From: Planning_THM <Planning_THM@environment-agency.gov.uk>
Sent: 19 April 2024 11:39
To: Dean Swann; Planning; Linda Griffiths
Cc: Katherine Miller; Louise Steele
Subject: RE: 10682 RE: CONSULTATION RESPONSE : 21/01119/OUT Our ref : WA/2021/129037/04

Subject: 10682 RE: CONSULTATION RESPONSE : 21/01119/OUT Our ref : WA/2021/129037/04

EA Flood Model Defended scenario 1 in 100yr +15%CC

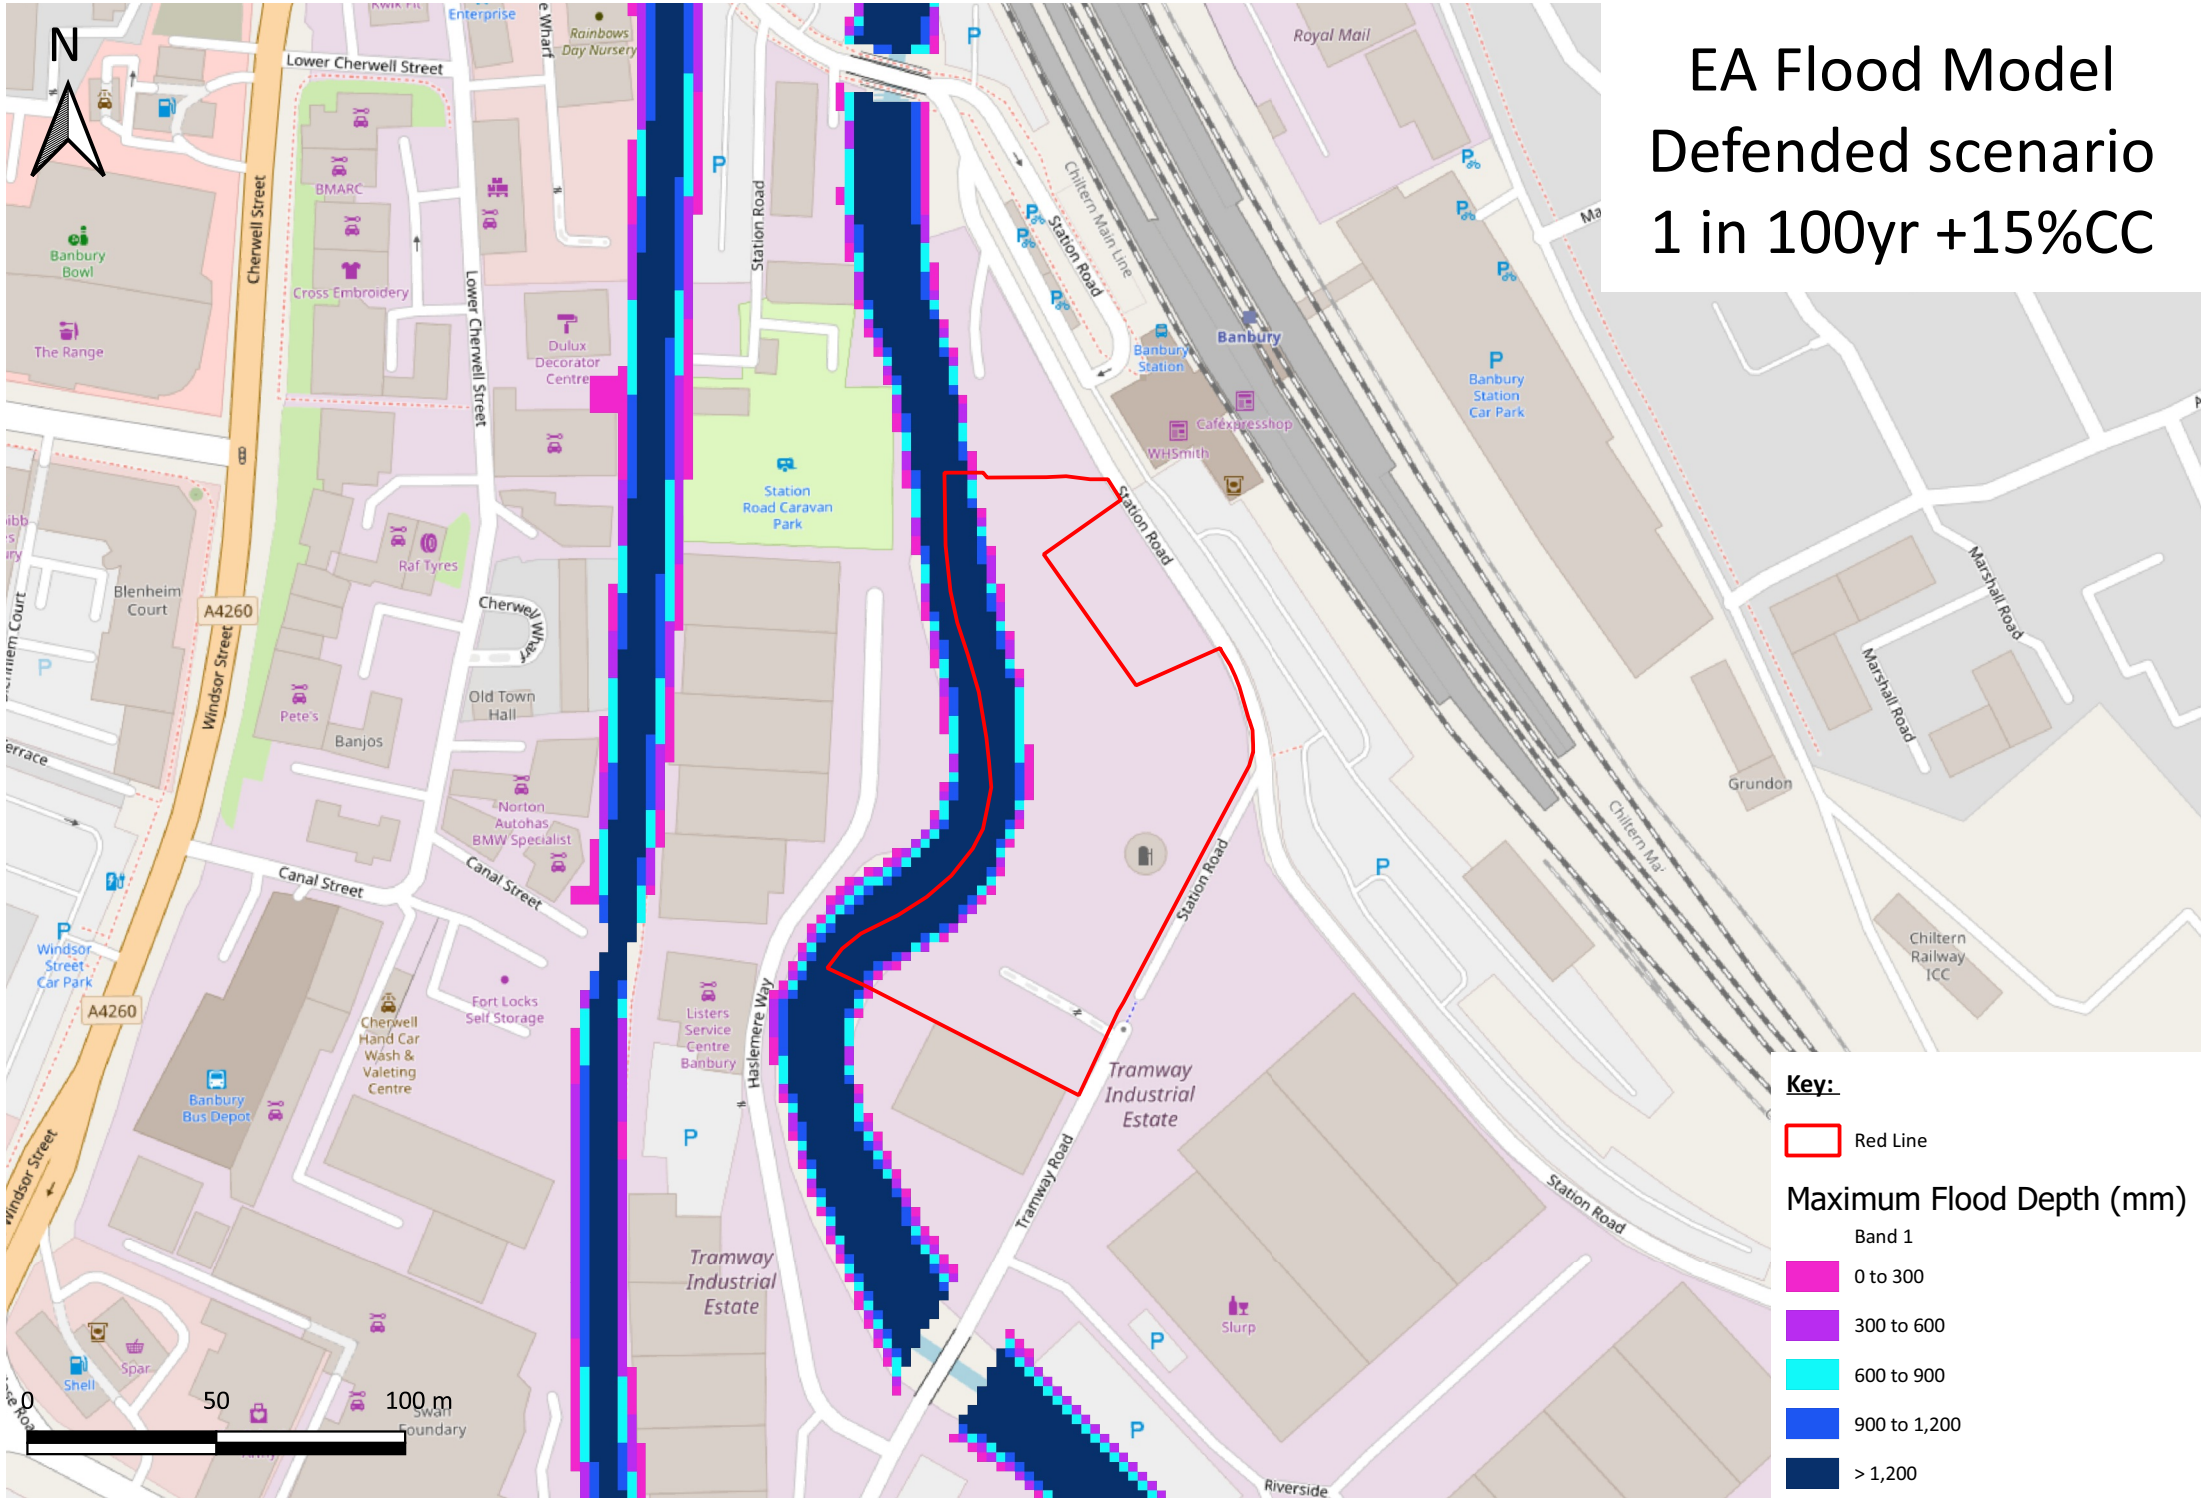
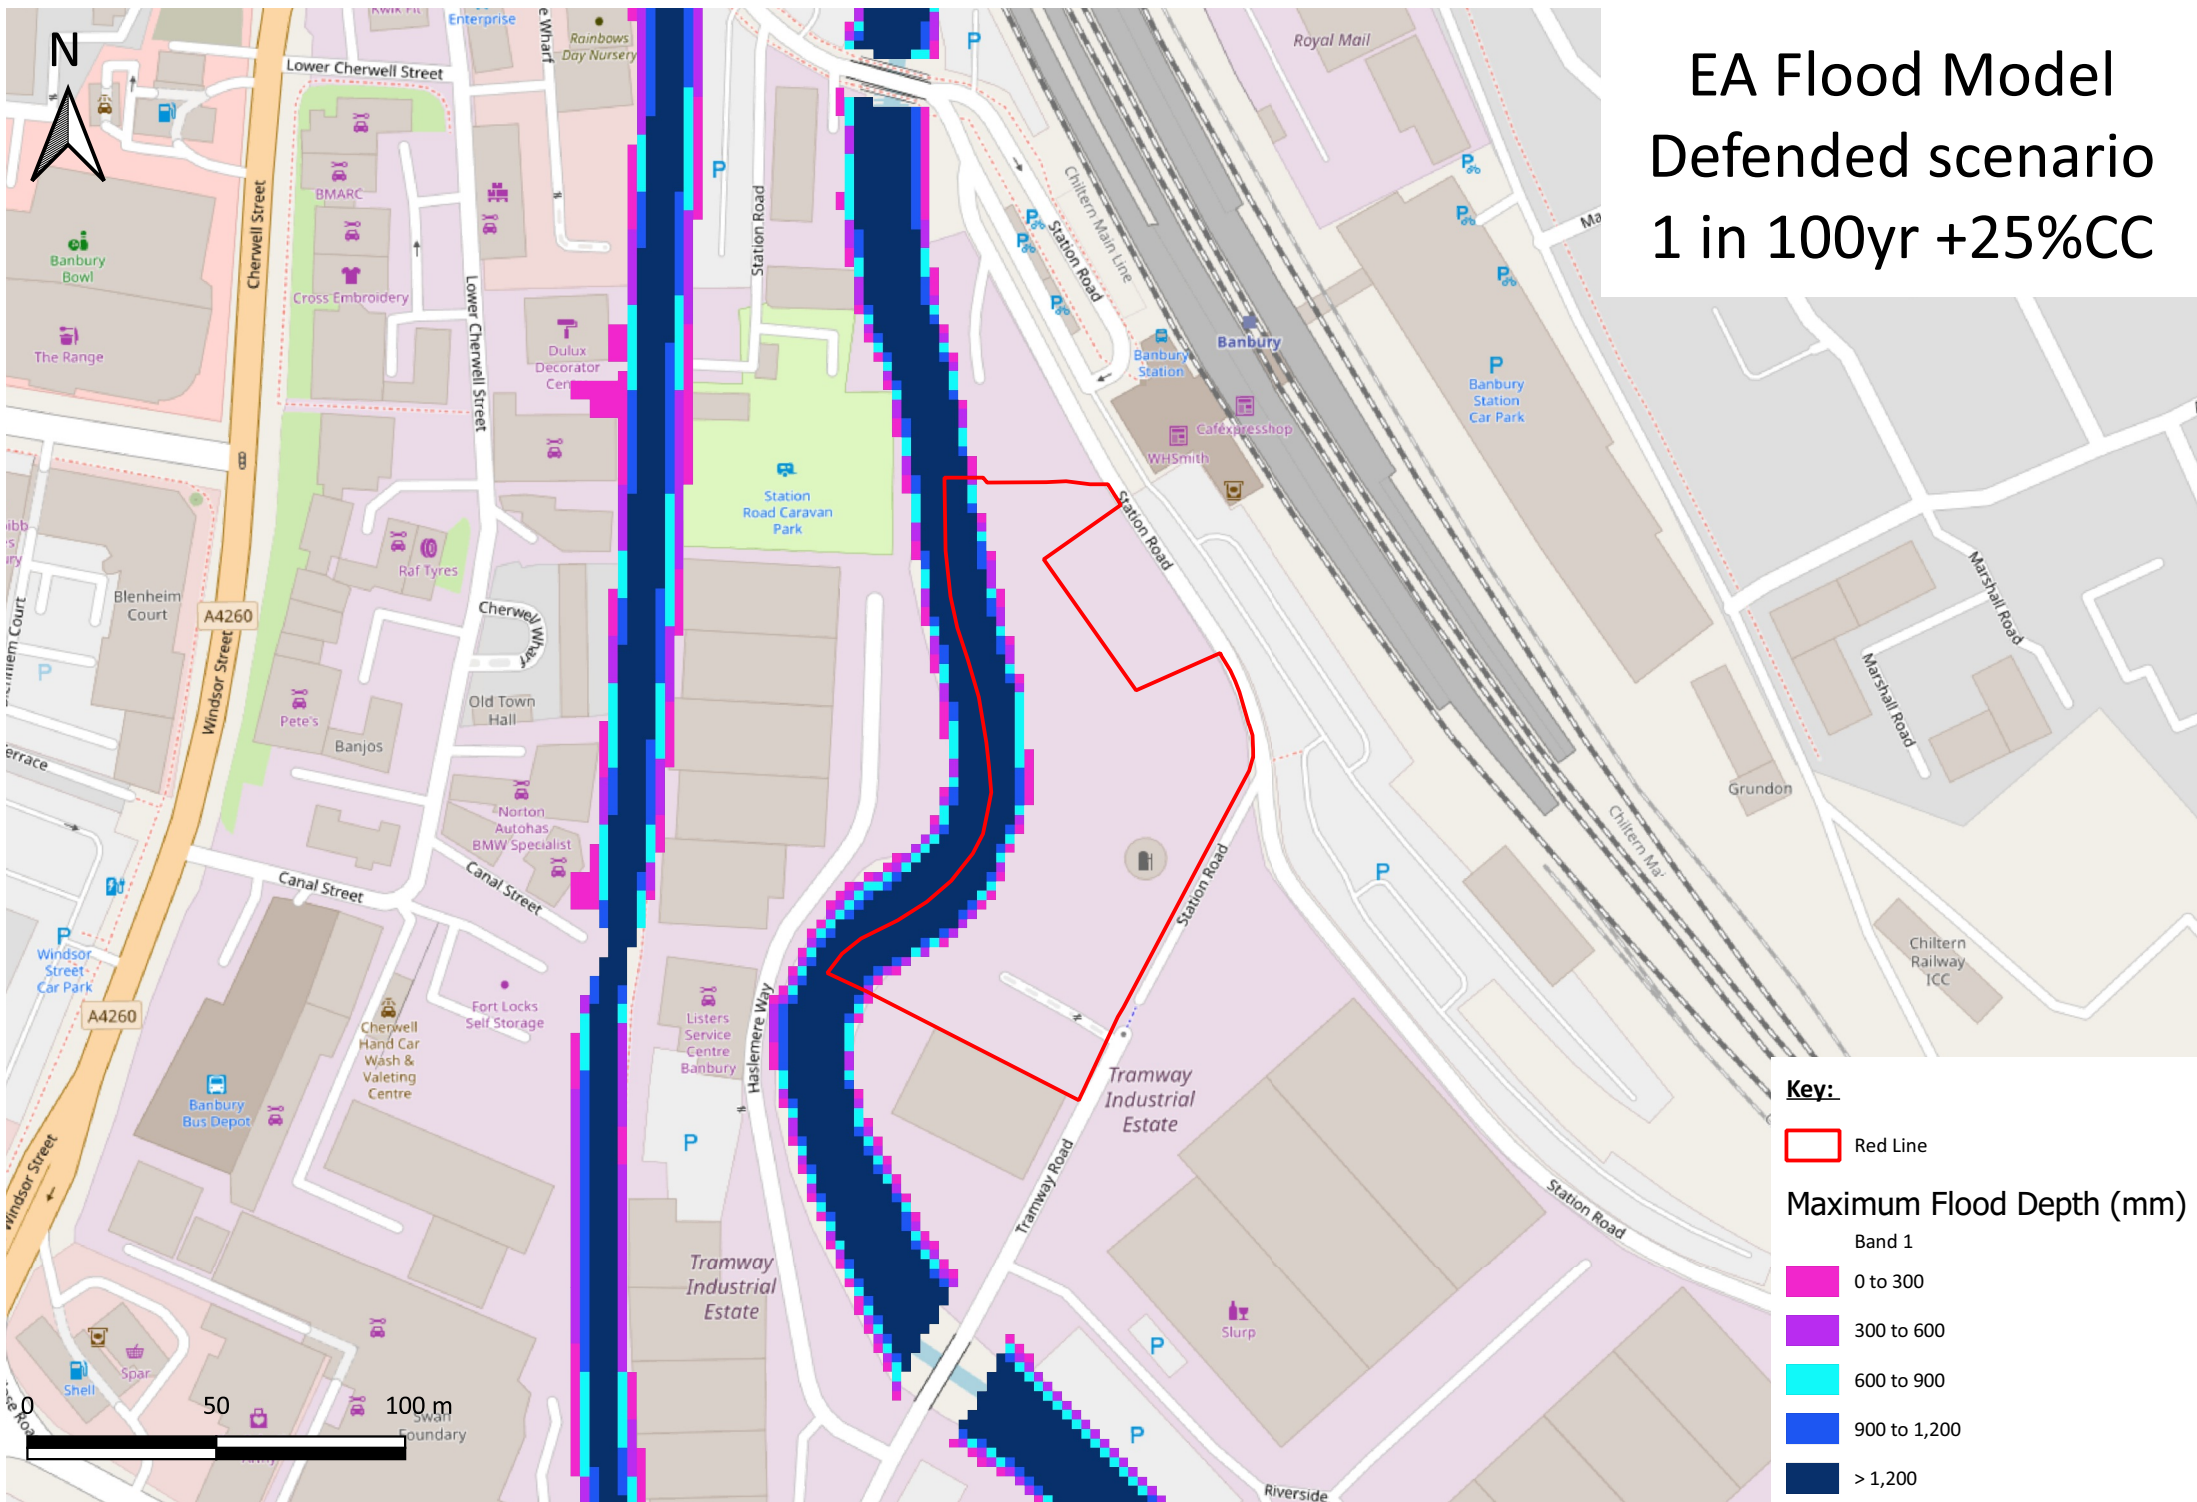
We don't understand why reference continues to be made the 49% cc scenario, this isn't necessary. Based on the current guidance for considering climate change for this catchment, you should model and map both the higher cc allowance (25%) and central cc allowance (15%) based on detailed site topography. Our best available modelled data shows there is an area of flood zone 3b (functional floodplain) along the river corridor. This is one of the reasons why 25% allowance should be considered. If all development can be accommodated outside of this extent (25%), avoiding the need for compensatory storage for lost floodplain, we would have no issue. If development is being proposed within this baseline extent, a loss of flood storage would occur and this will need to be compensated for and considered given if development within this extent would increase risk to the rail line and station. In this scenario, the compensatory flood storage would need to be designed to the higher cc allowance (25%). This is when a post scheme model would be needed alongside a detailed FRA.

Fundamentally, if we develop the site we have a larger footprint than there is there today. This being the case, any building, will by its very presence, displace more water during an undefended flood event than the site today. The site being a small city centre site is so enclosed, offsetting the volume in the flood plain is simply not going to be viable. Please see above comment. The sequential approach to the layout of the site is the best defence against flooding and our recommended option. If all development can be accommodated outside of the 25% cc extent then no flood storage will be lost. We would insist that no land raising takes place within the cc extent to ensure alterations in ground level doesn't itself lead to a loss of flood storage.
